Application for a Non-Material Amendment Following a Grant of Planning Permission

Change of use and conversion of redundant agricultural building to garage, workshop and gym area and to be used in conjunction with and ancillary to the existing evidential barn conversion.
Non-material changes are minor location of windows, removal of an outer store and levelling of the room line.

DOC 02022024-1 OLD GRAIN BARN non material change request

DC/21/02612

FRONT ELEVATION (East)

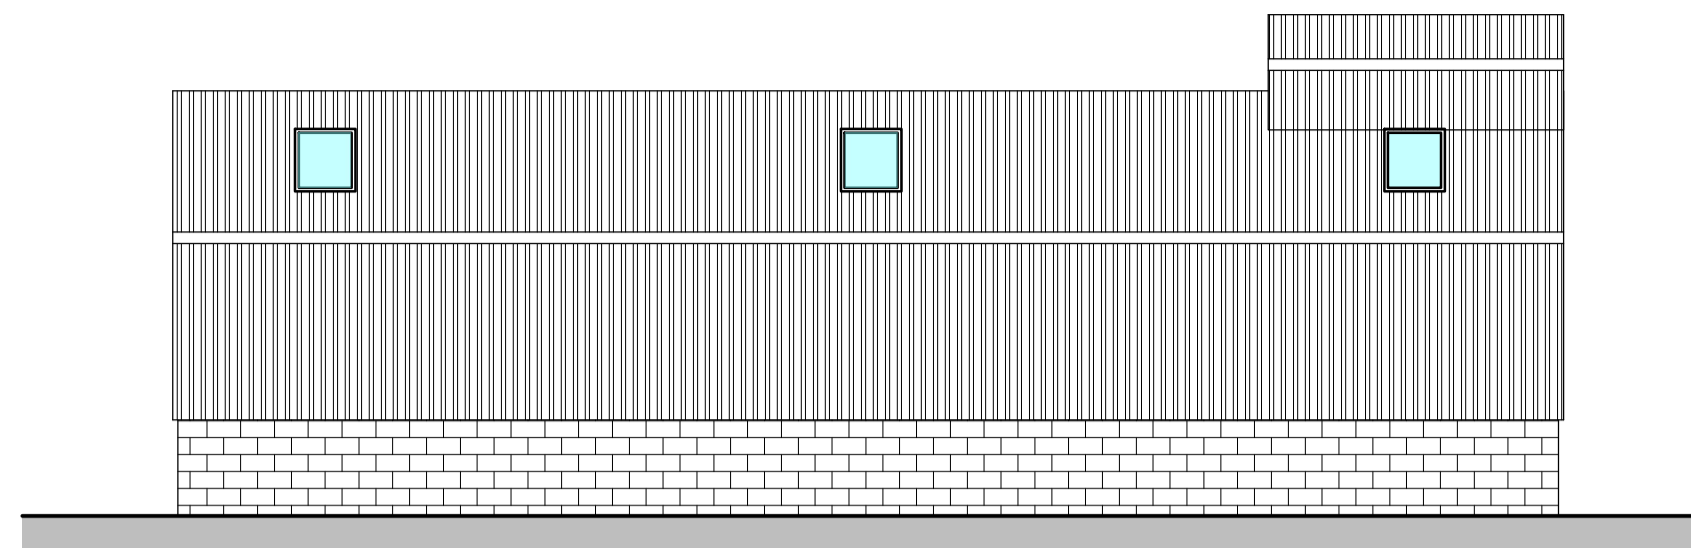
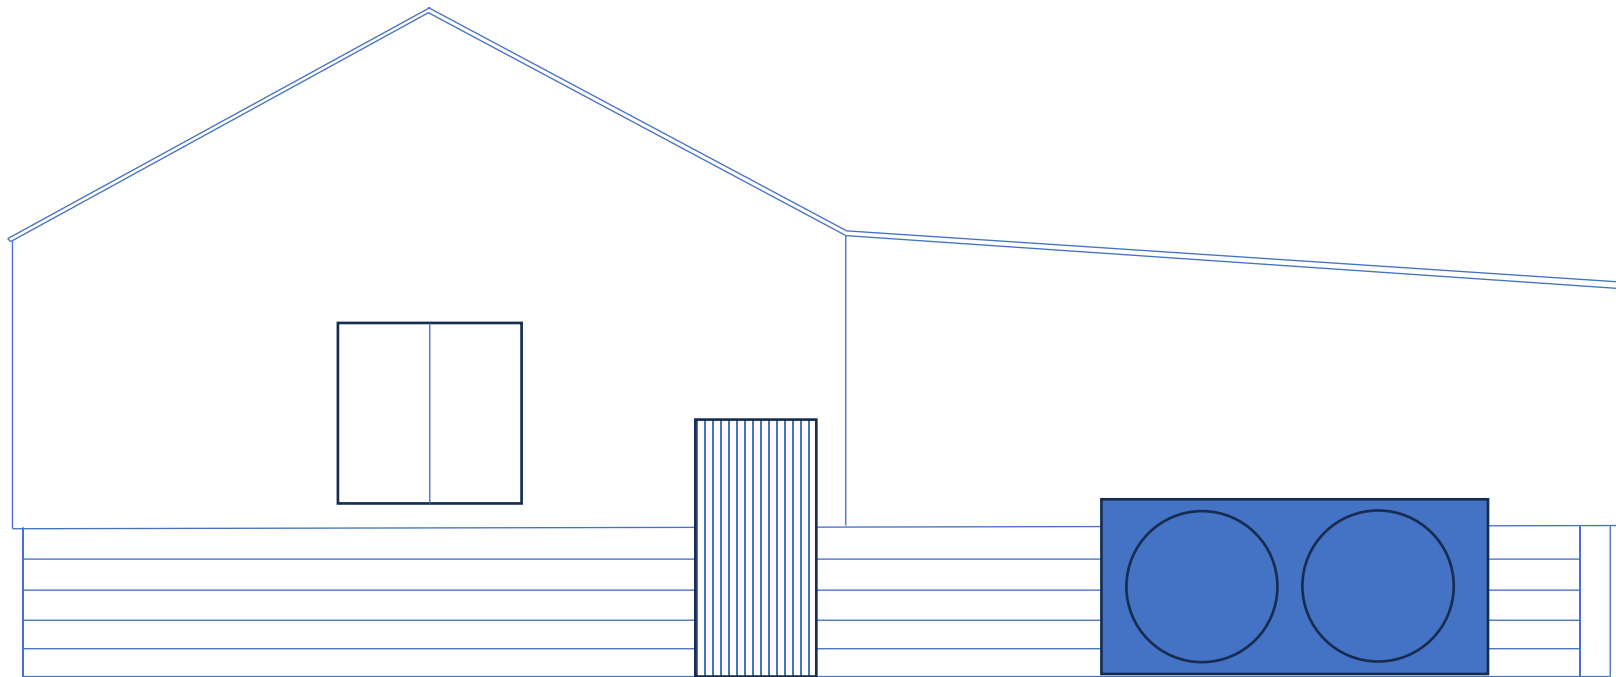
I would like to move the location of 1 door and a window on the side elevation south by approx 1m.
And move another to reduce the size of a window on the front elevation and move it to the left hand side as you look at the building.

In addition there is an external store sited on the front elevation that I would like to remove and there is a raised area on the roof that I would like to remove and level the roof line.

SIDE ELEVATION (South)

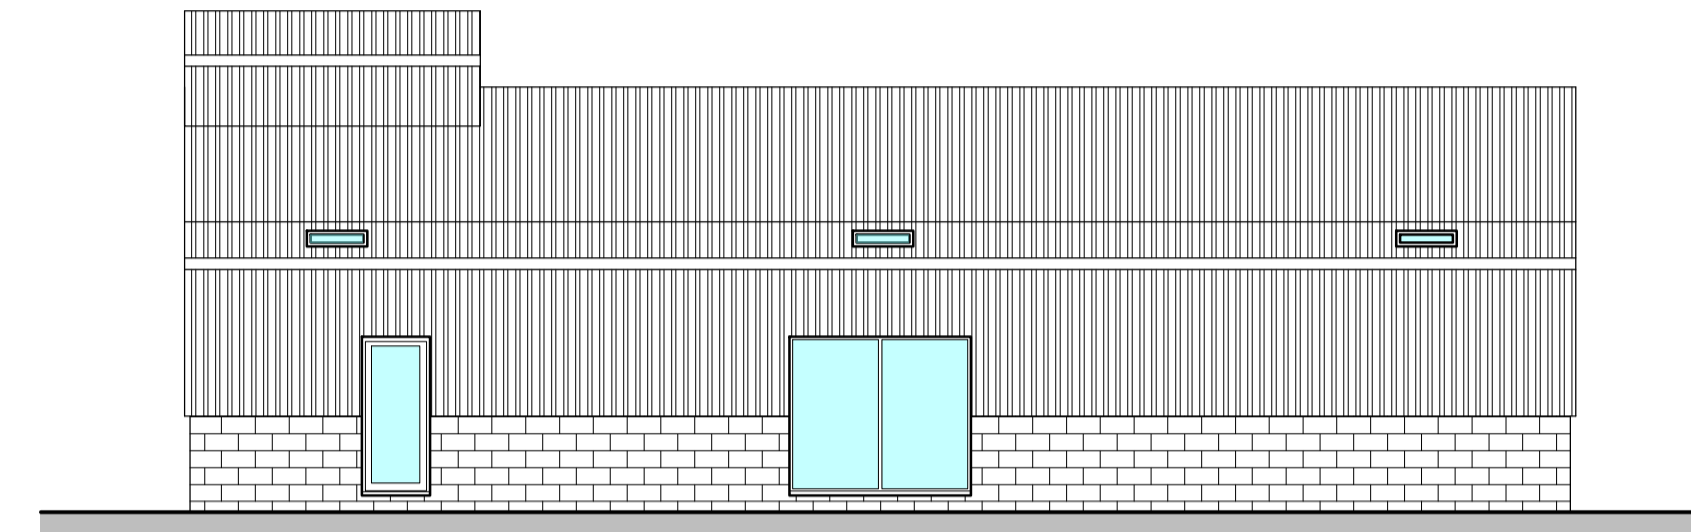
The reason for moving the windows is that builder placed the air source heating system for the main barn in this area and as such it is not possible to place the windows and door in the original position.
